**Notice of Exhibition of application for Inland Rail – Albury to Illabo (SSI-10055)**

Thank you for your referral dated 15 August 2022 inviting comments from the Heritage Council of NSW on the above State Significant Infrastructure (SSI) proposal.

FIGURE 7-3 THE MURRAY RIVER BRIDGE (AS PROPOSED)

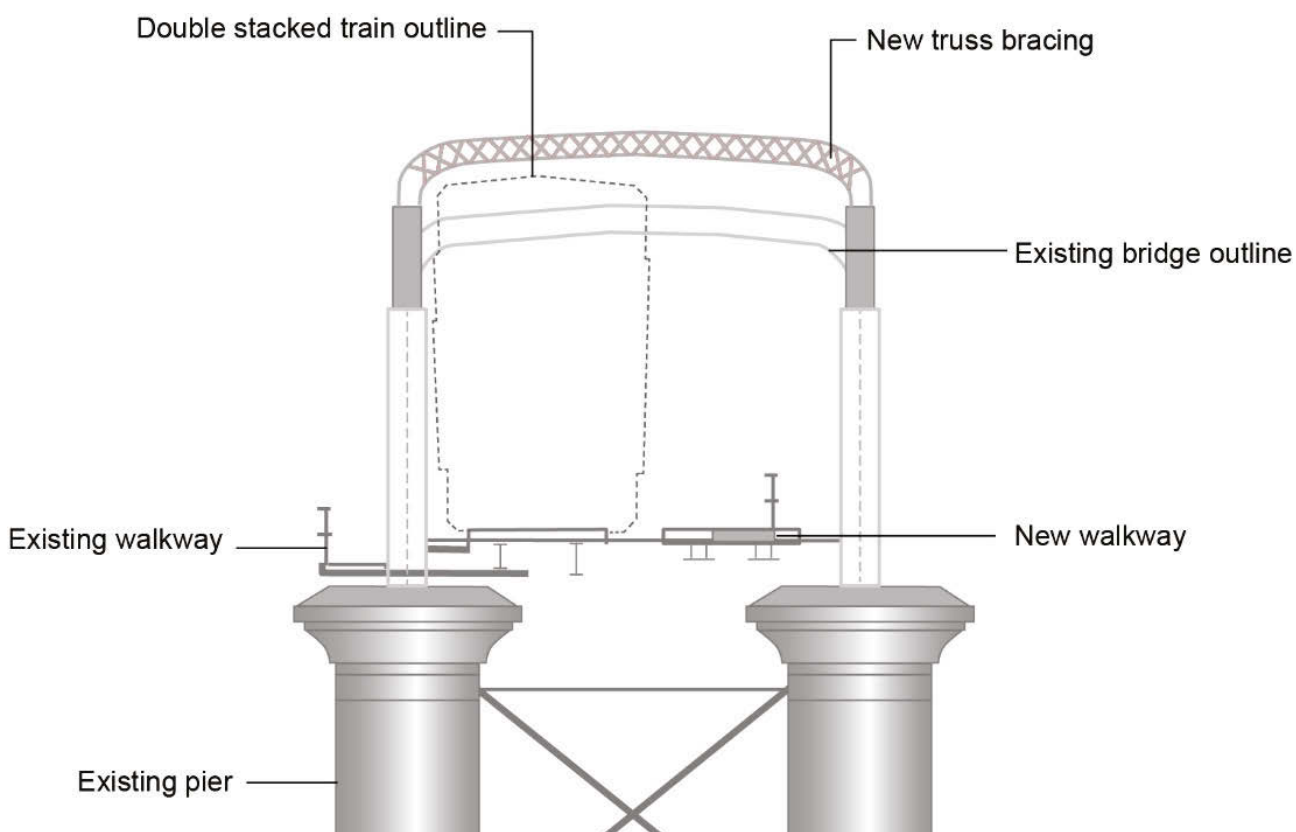
The proposal intends to remove the historic overhead bracing framework and install new replacement bracing, raised 2m above on stanchions. A new permanent walkway is proposed to the eastern side of the bridge. The bridge structure would require structural reinforcement along the downside lattice truss to allow the additional load of the trains and proposed elements. The existing paint is proposed to be removed and the bridge is to be repainted. Additionally, temporary works for construction are also proposed.

The historic overhead bracing is intrinsic to the material manifestation of the subject item's significance. It is noted that alternatives to raising the bridge height by removal and replacement of the overhead bracing were not possible. It is also noted that the submitted reports indicate that the bracing is currently in good condition. It is recommended that, as much as possible, elements of the overhead bracing structure are reused in the replacement structure. Should reuse not be viable, documentation should indicate the reasons why reuse was not possible and

provide probable relocation or alternate reuse spots. Alternatively, the bracing elements should form part of an interpretation strategy for the project. Any new materials proposed to be introduced to the historic structure shall be compatible with the historic fabric. Intrusions and intervention into the bridge shall be minimised as much as possible. Further, it is recommended that the proposed removal of graffiti and repainting be undertaken with consultation with the project's nominated heritage consultant. A site protection plan should also be in place to ensure that impacts resulting from the demolition are mitigated and the remaining historic structure is not damaged during construction works.

FIGURE 7-4 INDICATIVE EDMONDSON STREET BRIDGE

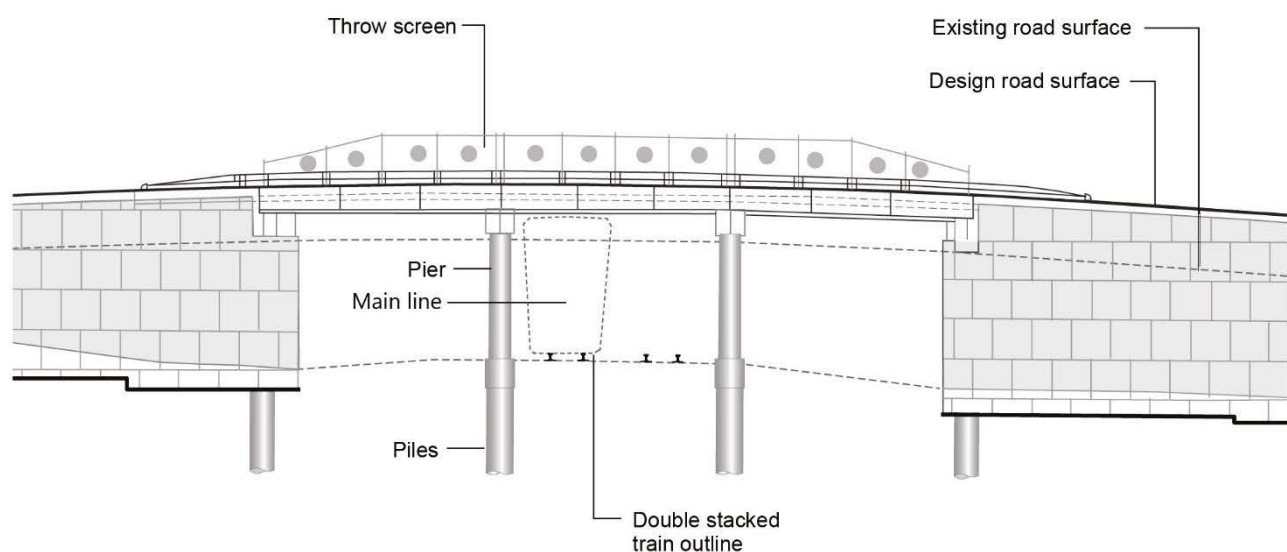
The Edmondson Street bridge is not within the curtilage of the SHR listed Wagga Wagga Station, however the significance assessment undertaken by GML Heritage indicates that the bridge may have potential for being of heritage value. Its demolition would have a visual impact upon the setting of the subject place.

The replacement structures are noted in the documentation as being larger than the existing bridges. It is recommended that the design and details of the proposed replacement bridges be undertaken with consultation with the project's nominated heritage consultant to ensure that visual impacts are minimised and that they sit within the aesthetic character of the historic yard group.

Figure 7-8 Key features of Albury Station and surrounds

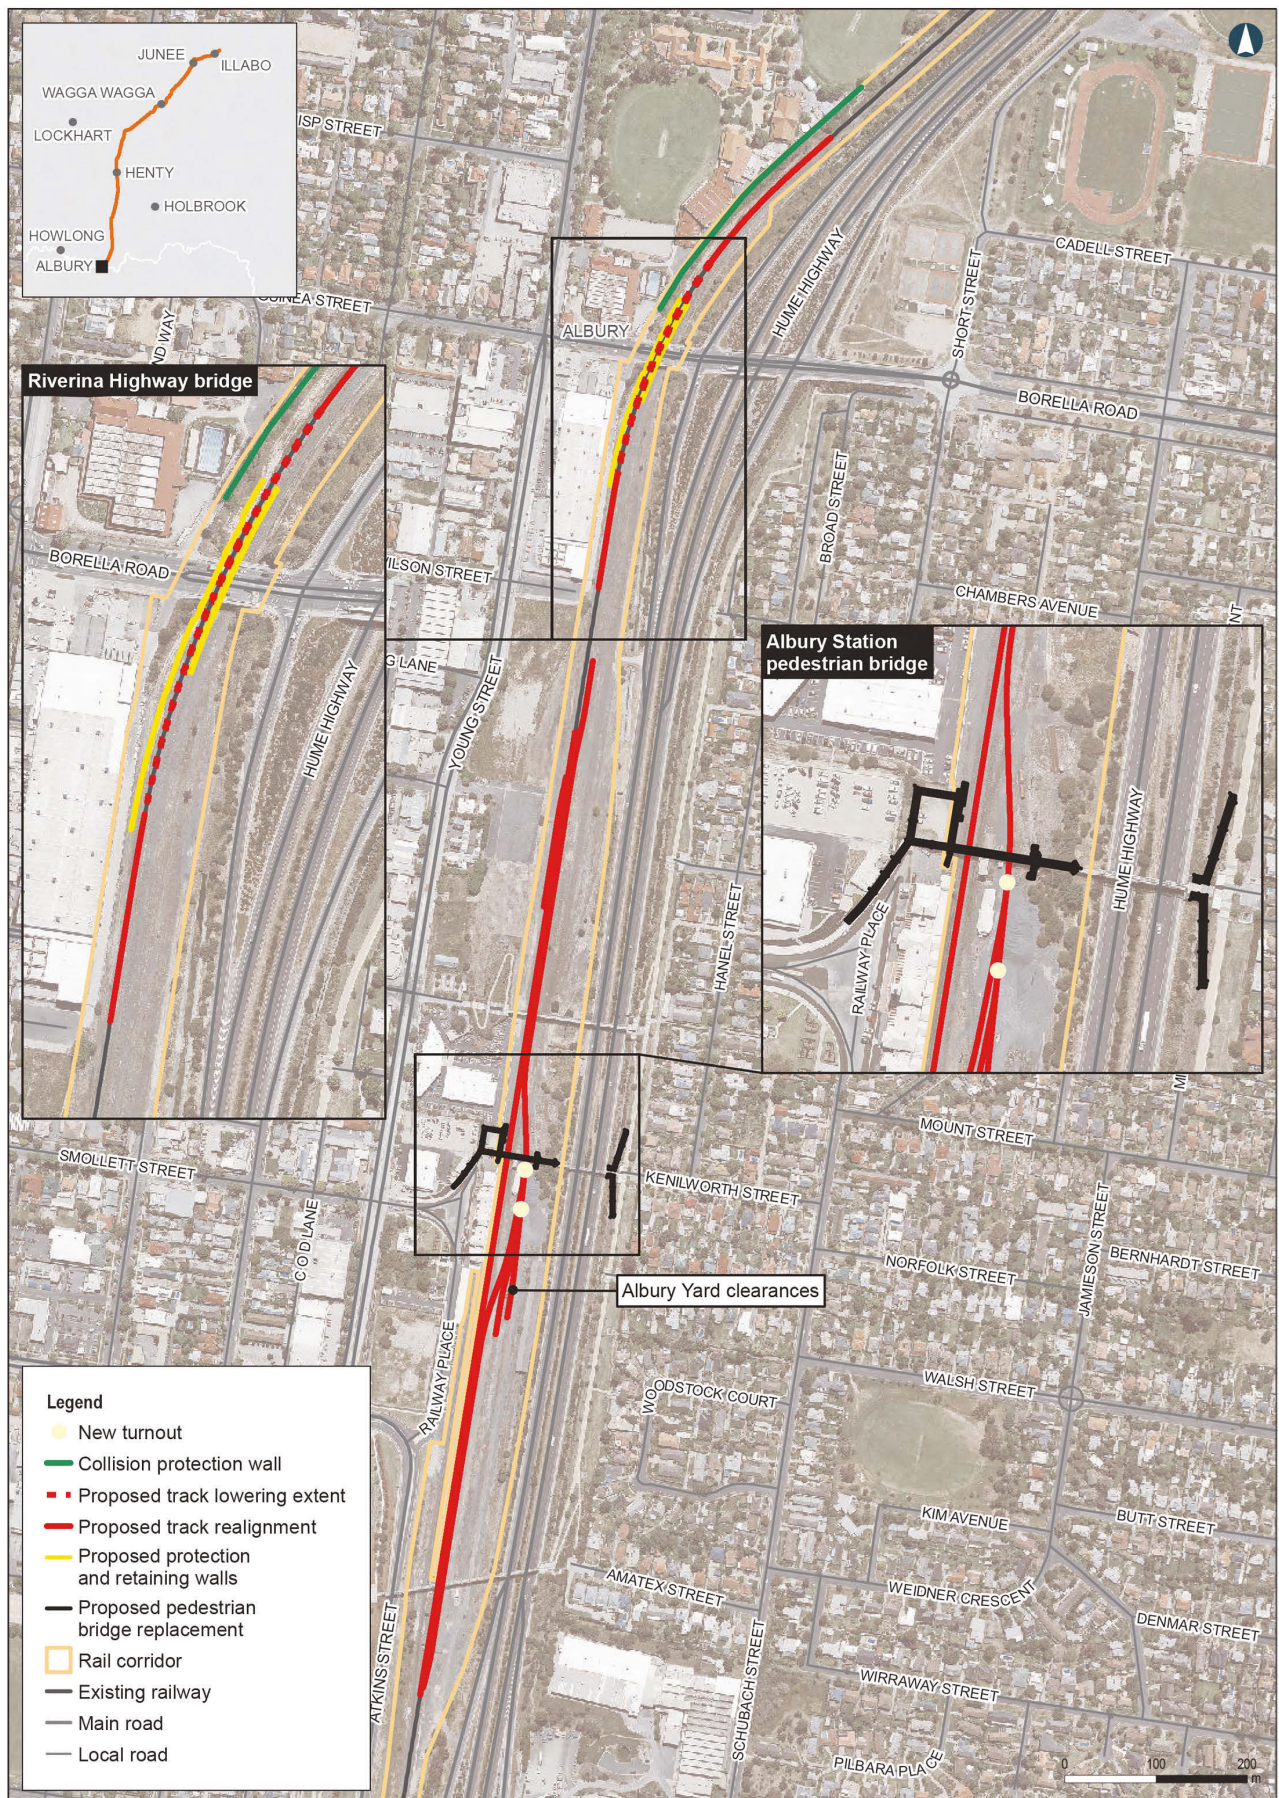
The proposal at Albury Railway Station includes the demolition of an existing pedestrian bridge and the construction of a new pedestrian bridge and demolition of Signal Box 1a. Track works include the removal of redundant track in proximity of the built heritage components and construction of new track over an area of archaeological potential (Broad-gauge railway tracks). New tracks and realignment of existing tracks would also impact Signal Box 1a. Temporary construction activities would also impact areas of archaeological potential.

It is noted that the proposed works at the Albury Railway Station would result in visual and physical impacts to the listed place. It is recommended that the proposed new pedestrian bridge be designed in consultation with the project's nominated heritage consultant to ensure that it is aesthetically balanced with its surroundings and the historic character of the yard and landscape.

The proposed elements for demolition shall be salvaged and reused, as much as possible on site and/or form part of the interpretation strategy. Further, a site protection plan should be in place to ensure that any impacts arising from demolition are managed appropriately.

HNSW notes that the documentation includes a program of test excavation to manage impacts to the archaeological resource – the broad-gauge railway tracks. It is recommended that the test excavations be undertaken prior to any approval granted for this application. The test excavation report should be submitted for review by Heritage NSW and its findings should inform the proposal, the Archaeological Research Design and any further detailed design.

Figure 7-15 Key features of Wagga Wagga Station and surrounds

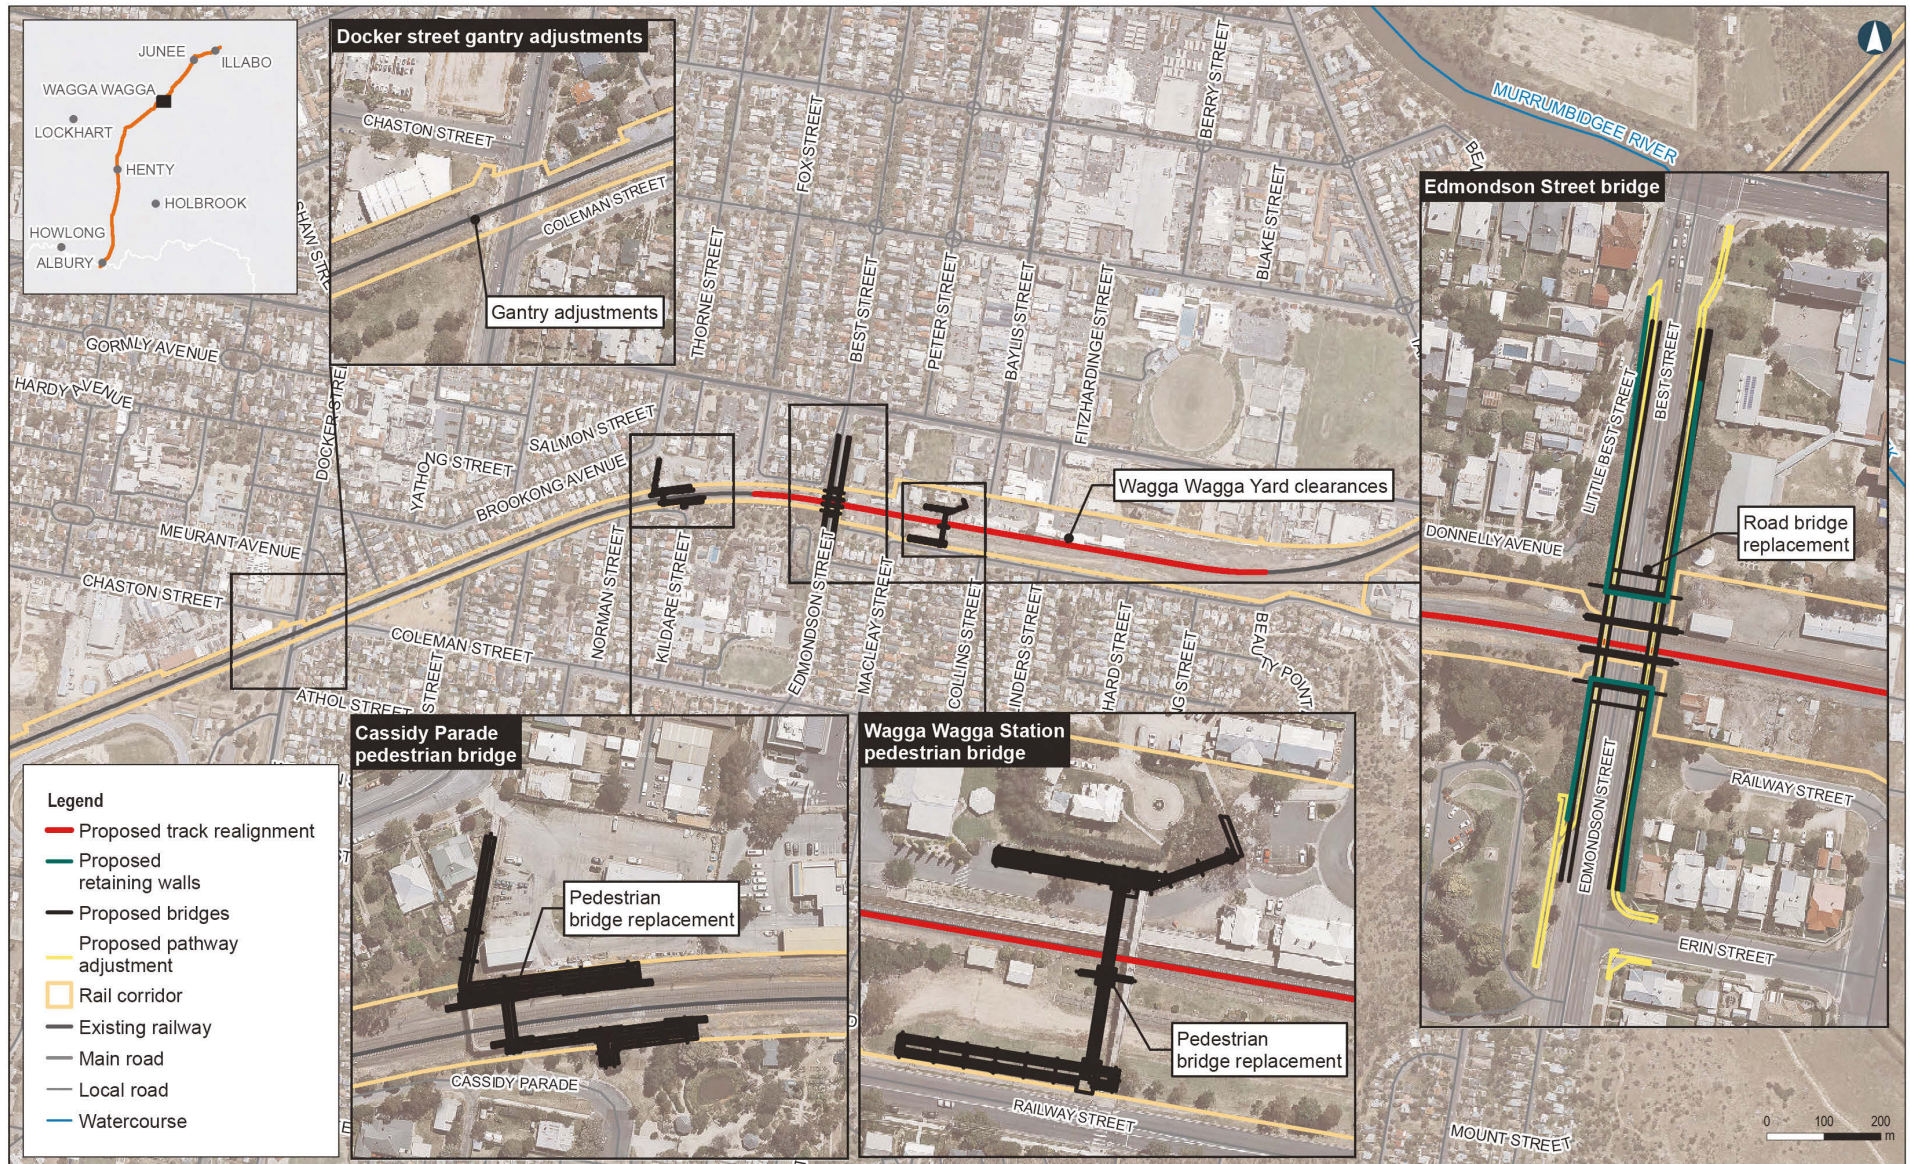
The proposal includes the demolition of the Wagga Wagga Railway Station footbridge and the Edmondson Street road-bridge and construction of new pedestrian and road bridges. Additionally, tracks are proposed for realignment and modifications to other rail infrastructure is proposed including removal of a gantry. Temporary construction works and compounds are also proposed.

Similarly, while the station pedestrian bridge is not specifically noted as having individual heritage significance, its removal would have an impact upon the setting of the Wagga Wagga Station.

It is also recommended that a site protection plan be prepared to ensure that the demolition of the bridges does not result in any direct impacts or damage to existing heritage structures in the surrounding areas.

Figure 7-18 Key features of Junee Station and surrounds

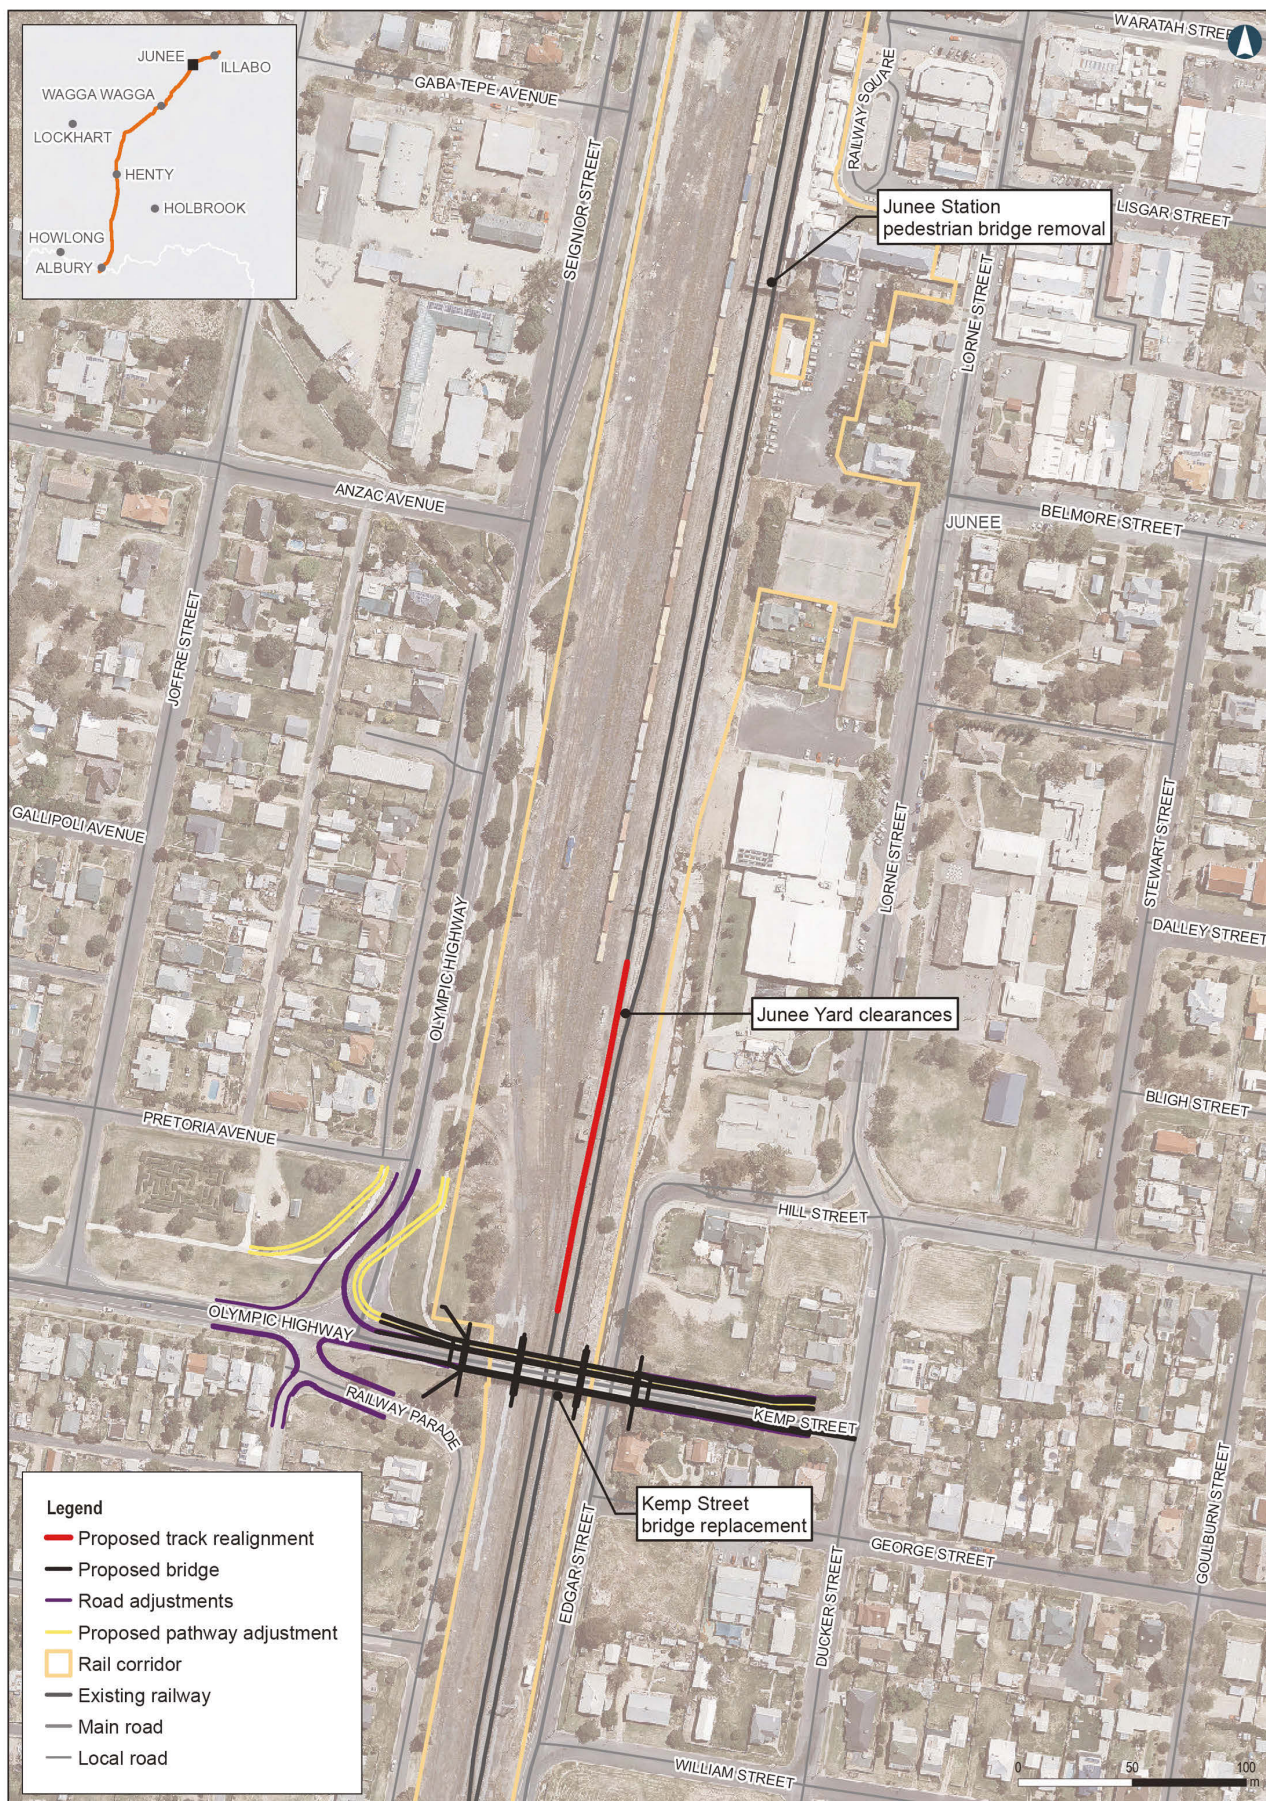
The proposal includes the demolition of an existing pedestrian bridge including the removal of footings from a station platform, adjustment to existing utilities and overhead signaling as well as trackwork.

While the pedestrian bridge is not described in the state heritage listing, the significance assessment undertaken by GML Heritage concludes that the bridge is valuable for being a rare example of a rapidly disappearing Warren Truss bridges along the NSW railway network. It is recommended that the fabric of the bridge structure be salvaged and reused within the proposed development and form part of the interpretation strategy for the project.

It is also recommended that a site protection plan be prepared to ensure that the demolition of the bridges does not result in any direct impacts or damage to existing heritage structures in the surrounding areas.
